EAGLEVIEW SUBDIVISION CONSTRUCTION DOCUMENTS

PCD FILE #: SF-22-42

EAGLEVIEW
EL PASO COUNTY, COLORADO
CONSTRUCTION DOCUMENTS
COVER SHEET

EAGLEVIEW EL PASO COUNTY, COLORADO CONSTRUCTION DOCUMENTS HORIZONTAL CONTROL PLAN

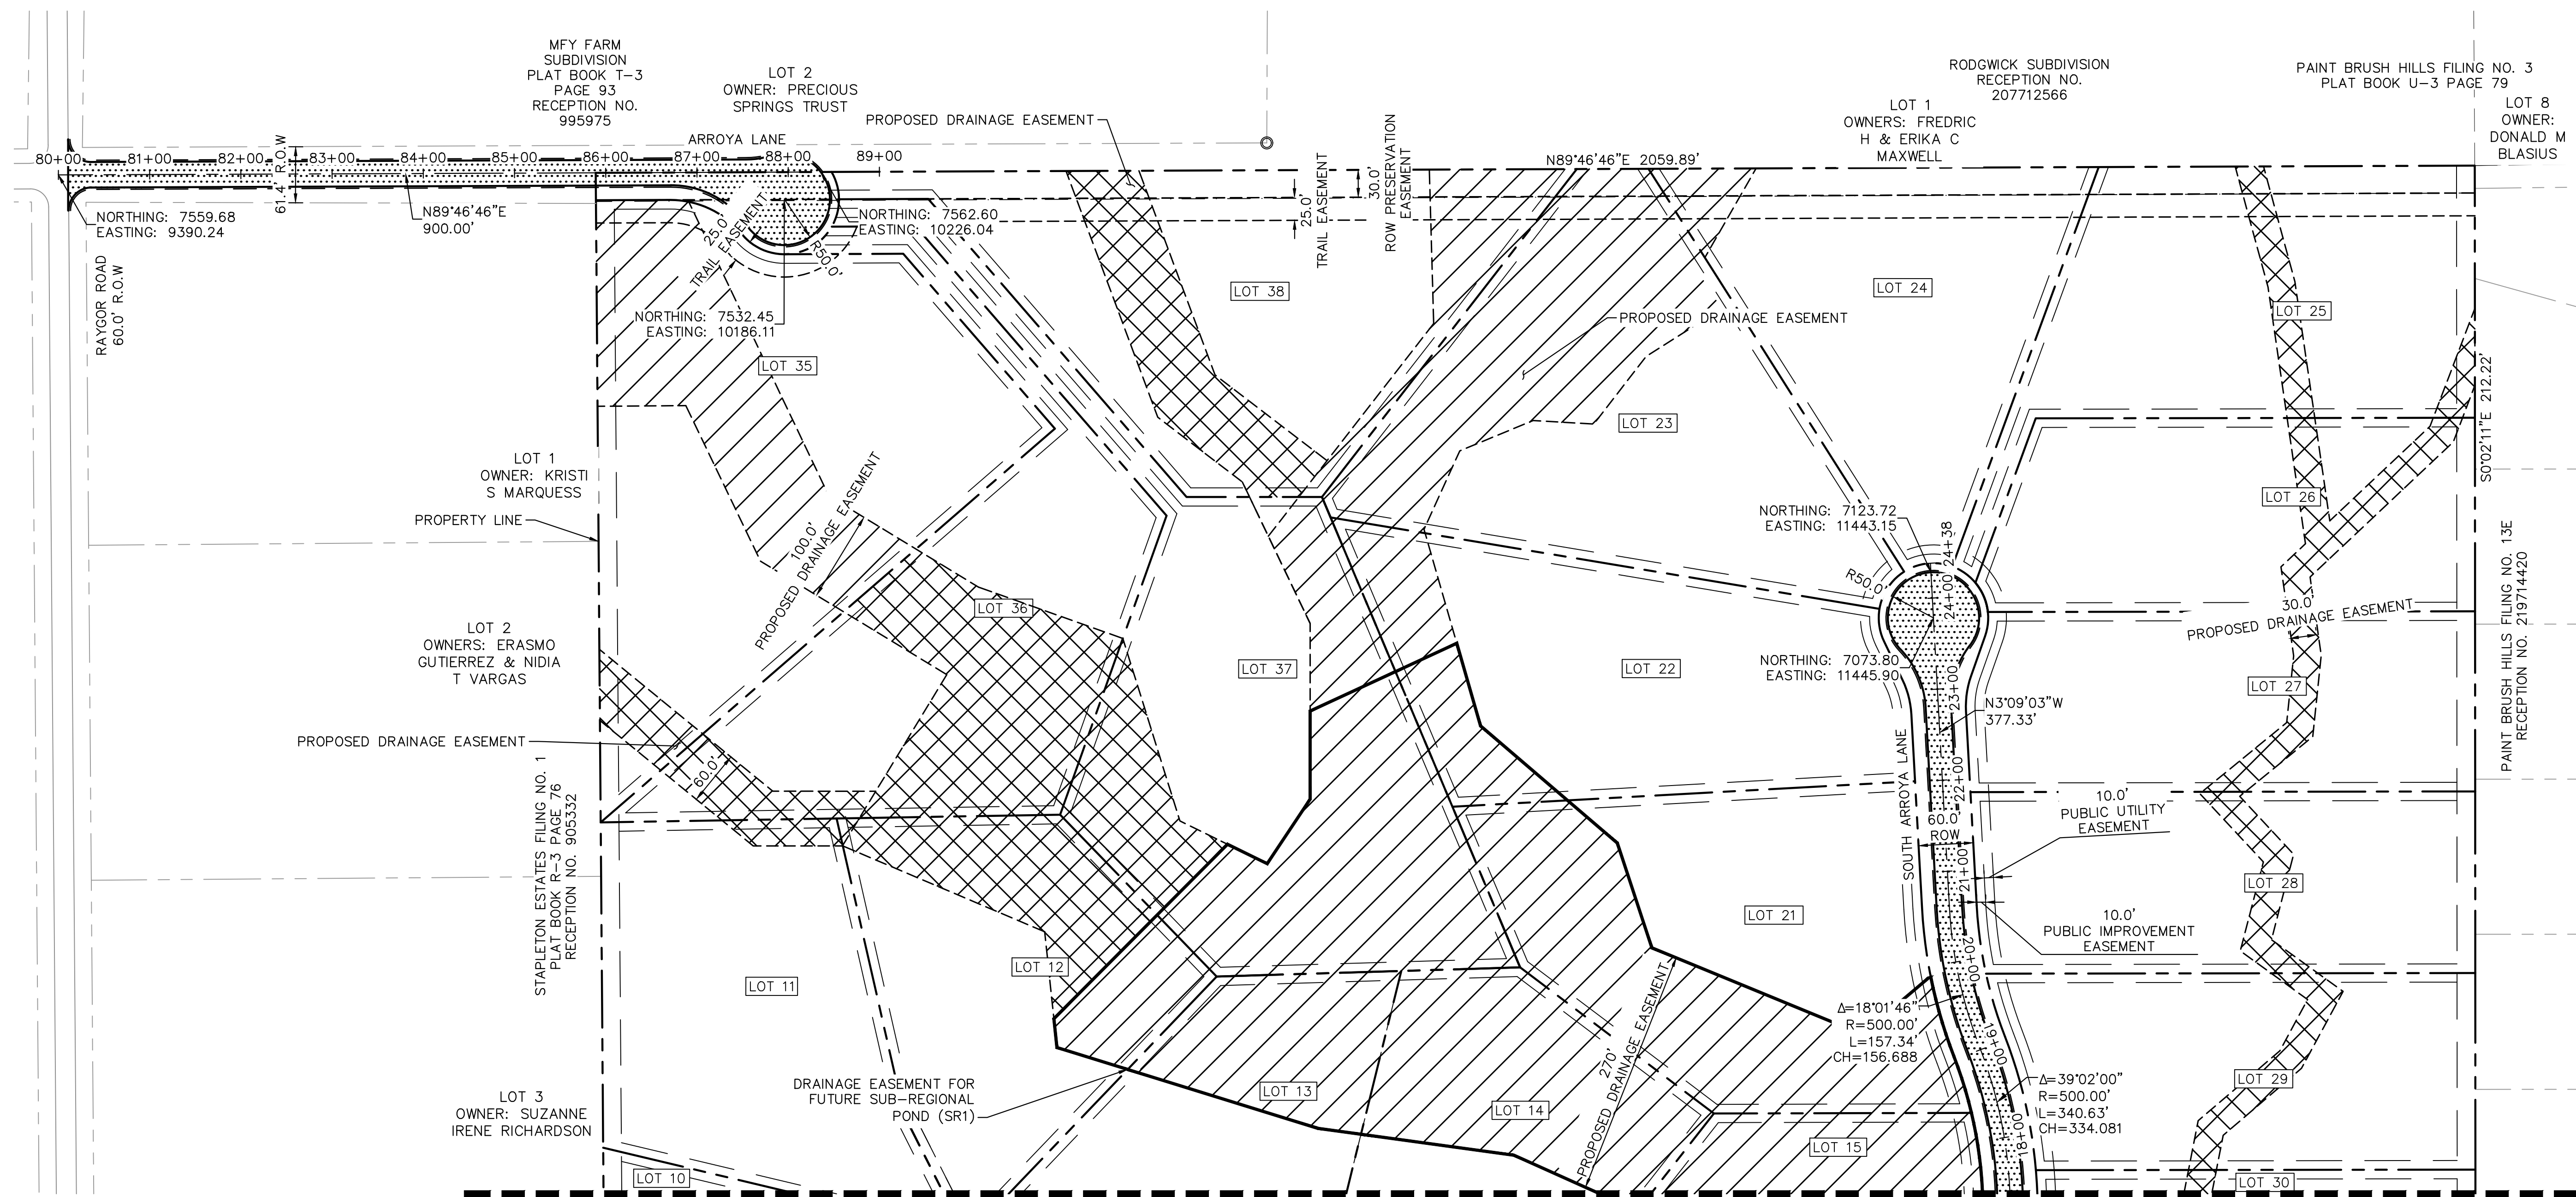
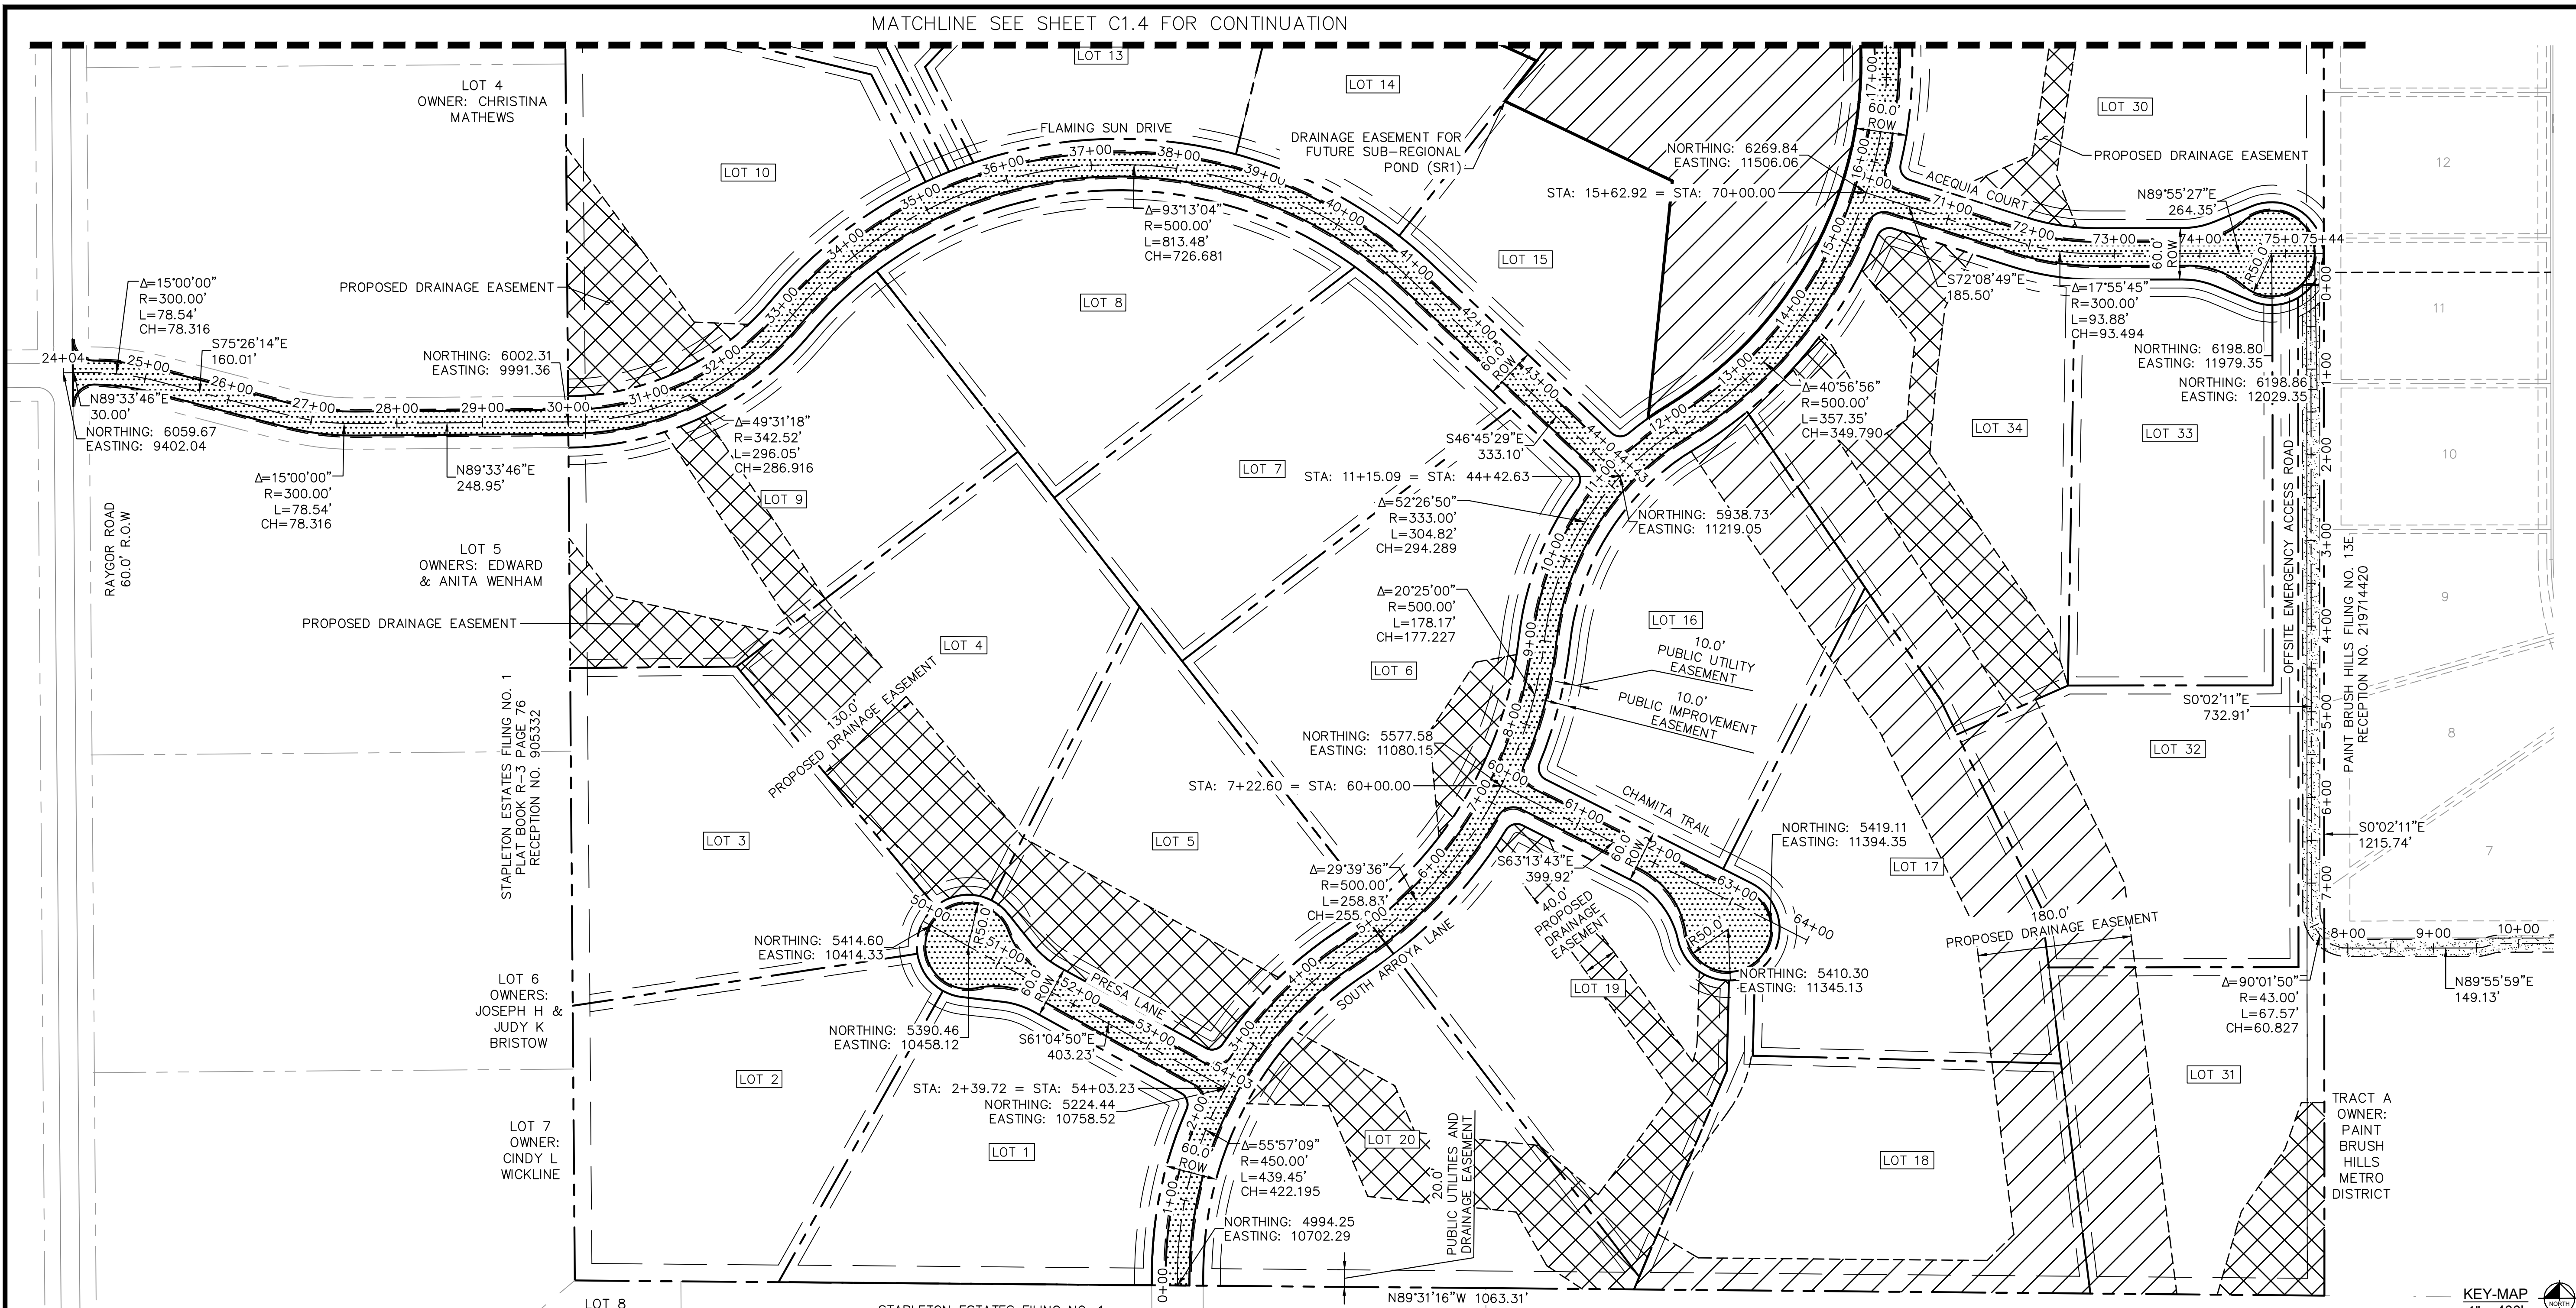
revise to County and Metro District

revise to County and Metro District
